From: [Richards_Huw](#)
To: [REDACTED]
Subject: A417 Missing Link - Registration to Speak at CPO session (2nd March) - Ref: TR010056
Date: 22 February 2022 14:33:22
Attachments: [image567939.png](#)
[image588443.png](#)
[image961201.png](#)
[image677644.jpg](#)
[image473565.jpg](#)

I wish to register on behalf of my client Hanson Quarry Products Europe Limited (an interested party) to speak at the forthcoming CPO session (2nd March) on in relation to the DCO Application by National Highways for the A417 Missing Link.

Drawing Title: **FIGURE 13.19 SCHEME HIGHWAY DRAINAGE - PLAN**

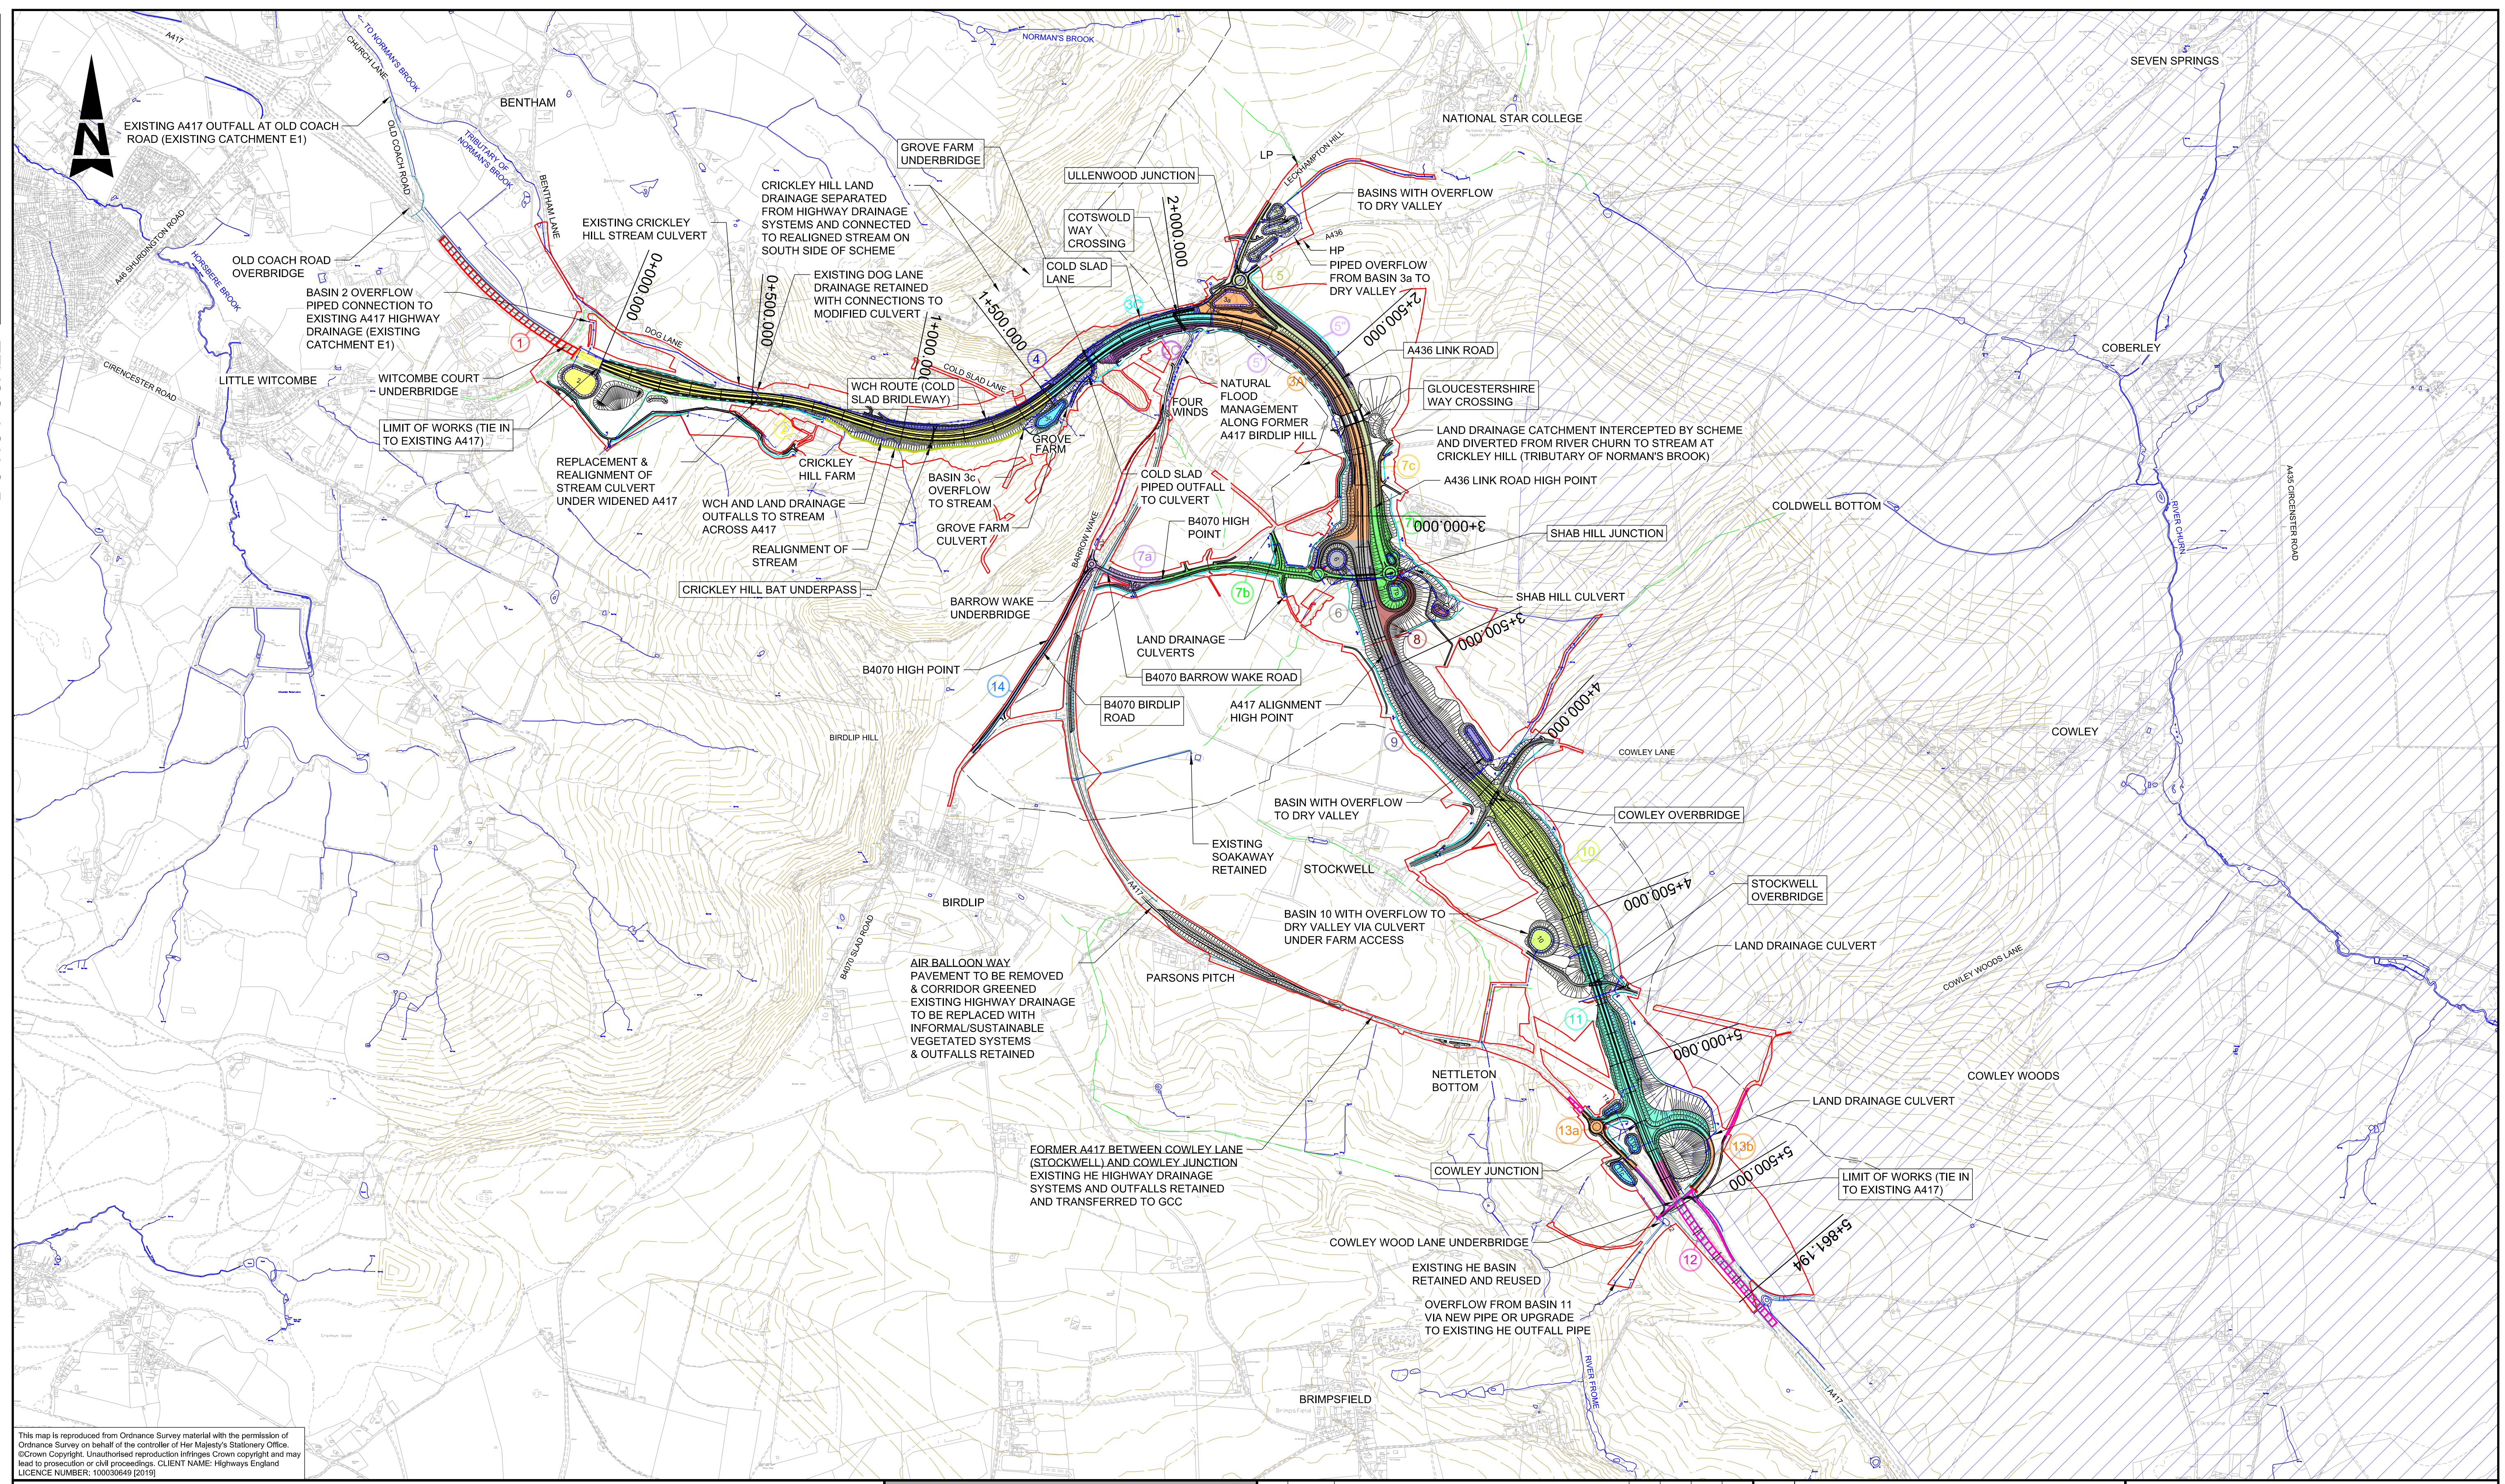
Having consulted the relevant Works plan it appears that this parcel of land is to contain a drainage ditch that flows from the proposed attenuation basin 11a and apparently outflows into my client's quarry? The Works Plan simply lists this as Works Item "Q" which we cannot identify in the relevant DCO documentation. The proposal for a drainage outlet into my client's quarry has not been raised to date in discussions with the applicant and it is of concern as my client is currently in discussion with the Planning Authority regarding re-activating their mineral planning permission and this would appear to have a major impact on future working.
